**100 BENNELONG PARKWAY,
OLYMPIC PARK**

ACCESS REVIEW

FINAL v2

13th June, 2014

2 Bed_T03E_Pre Adaptation 1:50
8 Units

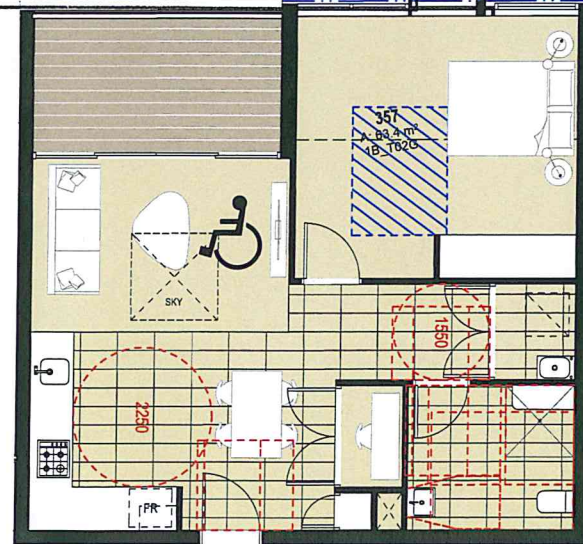
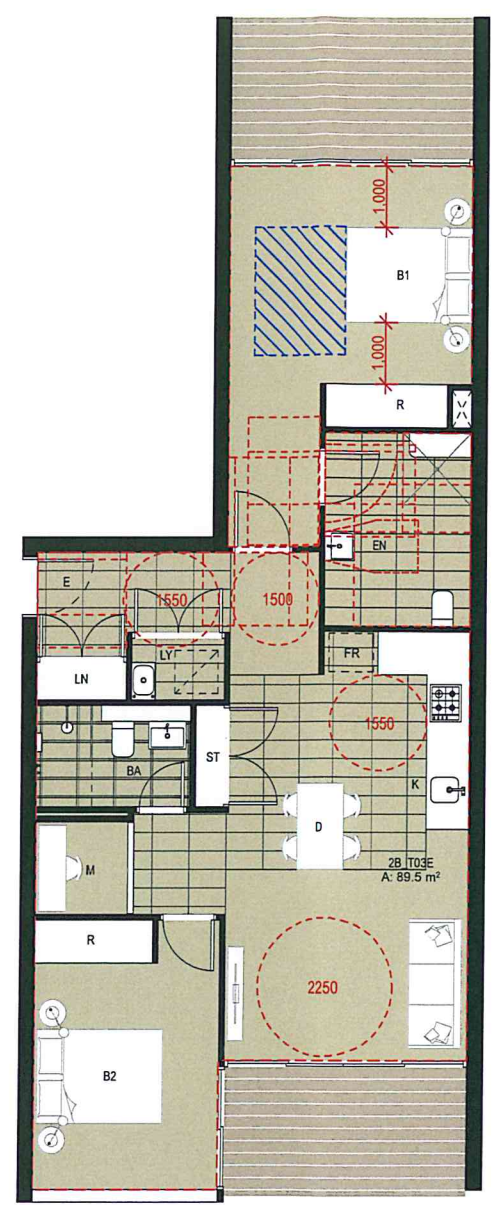
There is an accessible ensuite attached to the accessible bedroom. The bathroom has suitable internal dimensions to allow for appropriate clearances around the pan, basin and shower in accordance with AS1428.1. Modification is required to ensure compliance with AS4299.

- (i) The bathtub to be removed requires continuous waterproofing and tiling underneath/behind from the outset to allow for ease of adaptation.
- (ii) Consideration for adaptable unit balconies to be wheelchair accessible. Provide 35mm max. height variation (eg. slab set-down) between areas to allow for use of a removable 1:8 threshold ramp, compliant with AS1428.1:2009 (advisory)
- (iii) If balconies are not accessible as above, height of external balustrade to be increased in height to satisfy BCA requirements at pre-adaption stage as provision for raised external decking/paving for future wheelchair access.
- (iv) Provide slip-resistant floor surface with min. wet pendulum test rating of 'X' (under HB197/AS4856) in adaptable unit bathroom, kitchen and
